Please ask for: Sian Eggington
Email: sian.eggington@terraquest.co.uk
Telephone: 0121 234 1390
Our Ref: P/28/22/L
Your Ref:
Date: 23rd February 2022

Listed Building Consent for Alterations, Extension or Demolition of a Listed Building

Development: Rear extension
Location: Neals Farm House, West Wing Lower Bognor Road Lagness PO20 1LW

Block Plan
Scale: 1:500

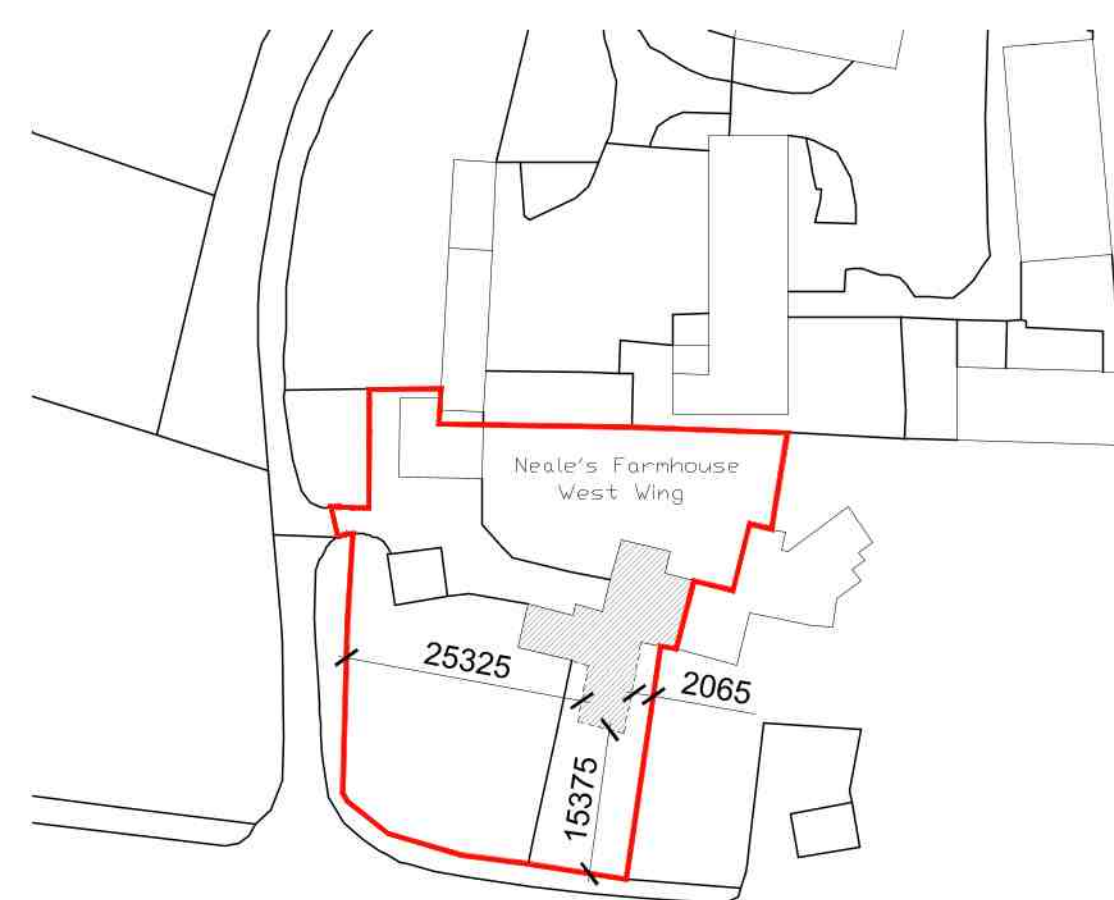
Dimensions: You are required to include dimensions on the block plan from the proposed extension(s) to ALL site boundaries. Please amend.
